Our Ref: BN/64/21/NMA

Non material amendment following BN/24/20/PL to incorporate an integral garage into the building and other alterations to the fenestration arising from the rearrangement of the internal accommodation.

Tile Barn Farm 32 Hill Lane Barnham PO22 0BL

PROPOSED PLANS
Dwg. No. 03

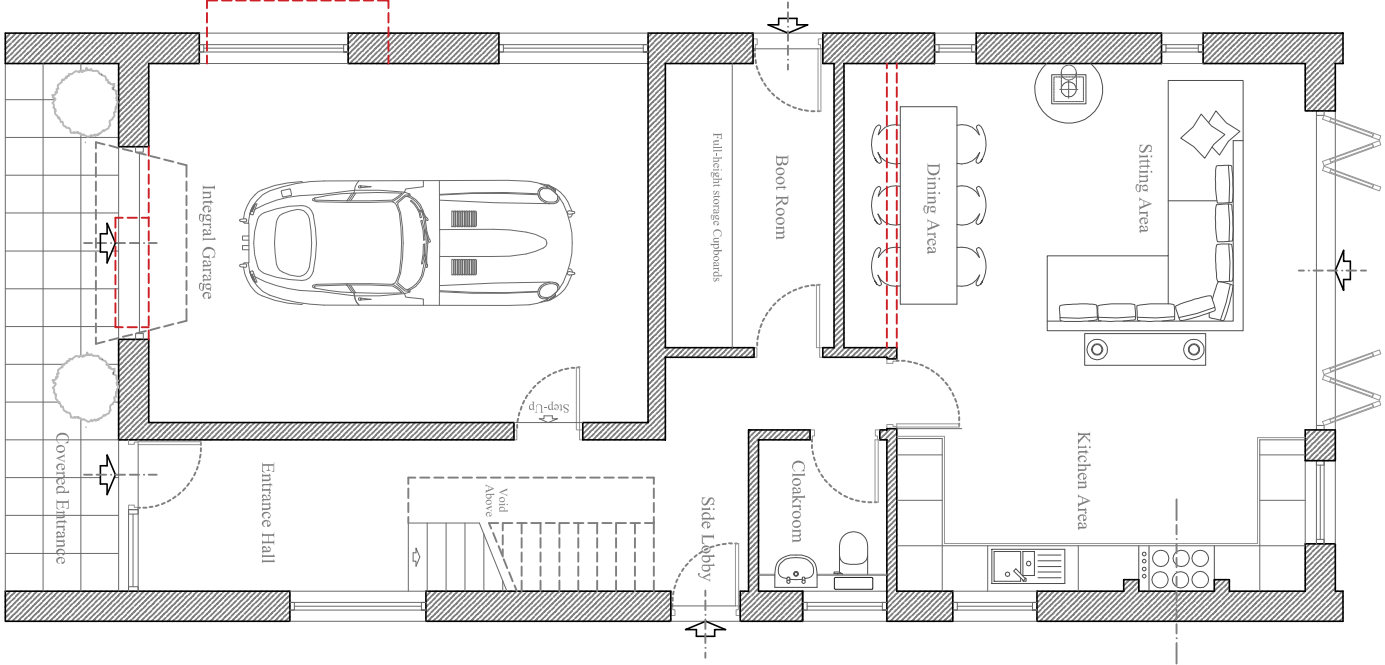
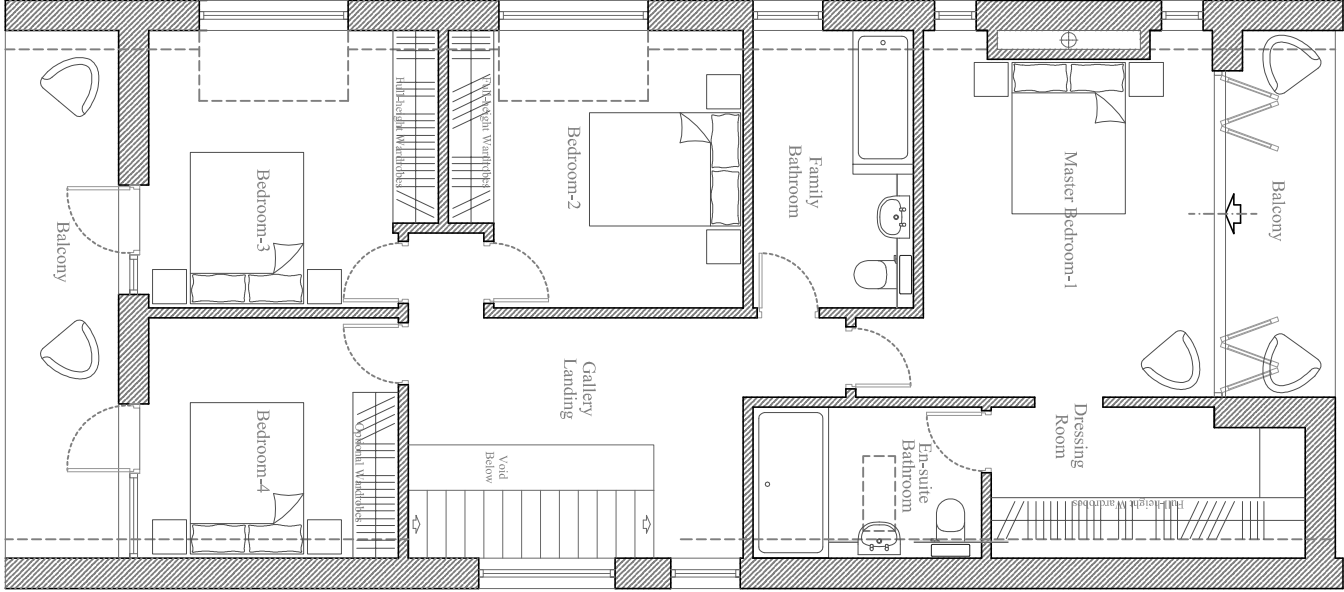
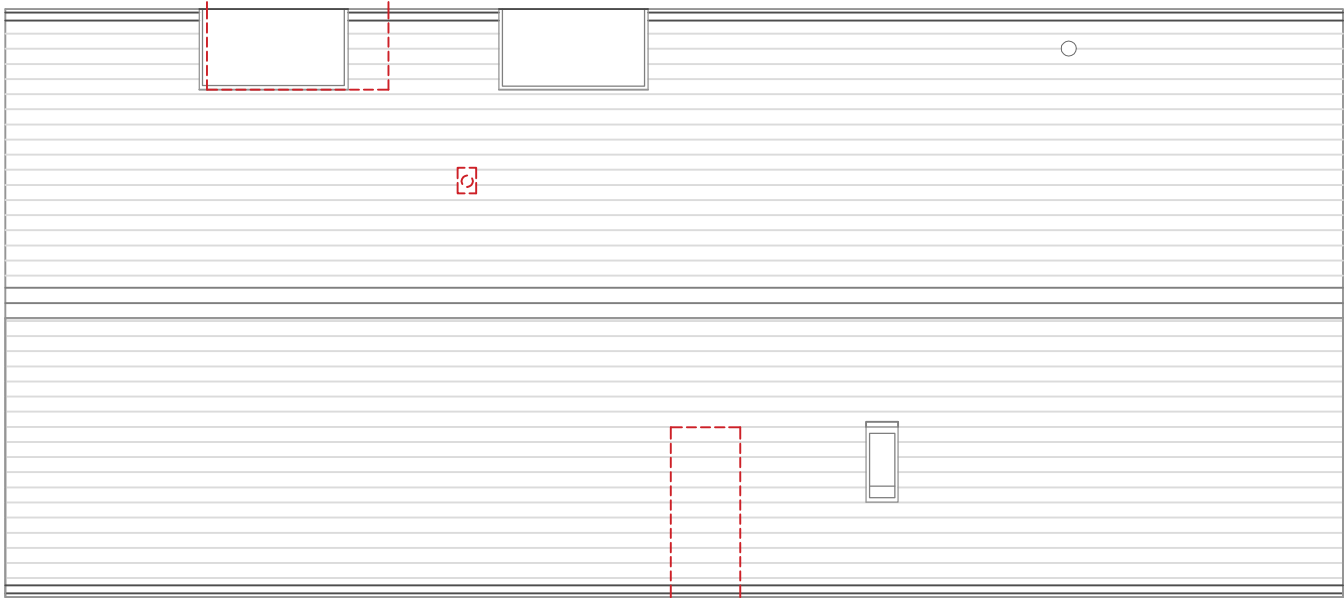
The reasons that these proposal has been accepted as Non-Material Amendments is because the changes do not materially alter the planning permission, do not necessitate additional consultation with local residents, do not breach planning policy and do not enlarge the building. It is accepted that an integral garage would be incorporated into the dwelling, replacing proposed study and sitting room, the western(front elevation) French window would be replaced with garage gates.

There would be further changes in fenestration arising from the revised internal layout; a bay window on norther elevation would be replaced with non-projecting smaller window, reduction in fenestration on first floor level on western elevation above the doors, fenestration reduced on southern elevation by removal of element that extends into the roof, wrap around glazing on the north-eastern corner would be replaced with bi-fold doors on the eastern elevation, new

windows would be inserted at ground and first floor level on the north elevation to match those adjoining. On the eastern elevation the fenestration would be reduced at first floor level above the opening doors, the doors would be reconfigured and side opening to the balcony removed, the window to bedroom 3 on the northern elevation would be reduced in width. Metal log burner flue would be repositioned, closer to the eaves.

Please note that the drawing 03 Rev B replaces the originally approved the drawing 03 and the drawing 04 Rev B replaces originally approved drawings 04 and 05.
